**SUBJECT: ECOM2009-0010  
ELECTRICAL COMMERCIAL**

Here are the results of all Inspections located at **503 CALVARY CHURCH RD:**

Inspection Type: FINAL\*\*  
Scheduled Date/Time: 11/13/2020  
Completed Date/Time: 11/13/2020  
Inspector: Scott Guy  
Result: DISAPPROVED  
Remarks:

SITE PLAN	
SHEET NUMBER:	REVISION:
C-101	0

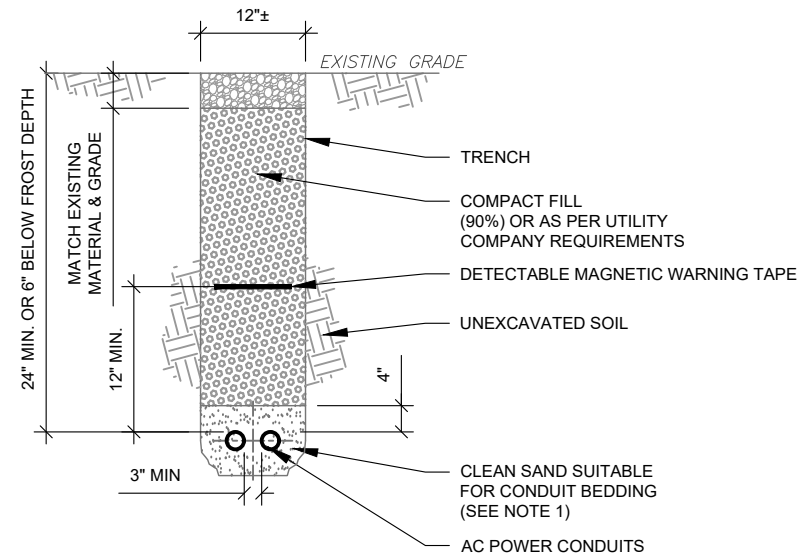
Notes: gate code is 1760 if any question or need assistance call Brenda at 469-338-7618  
Water running out of electrical conduit elbow of cabinet next to generator.
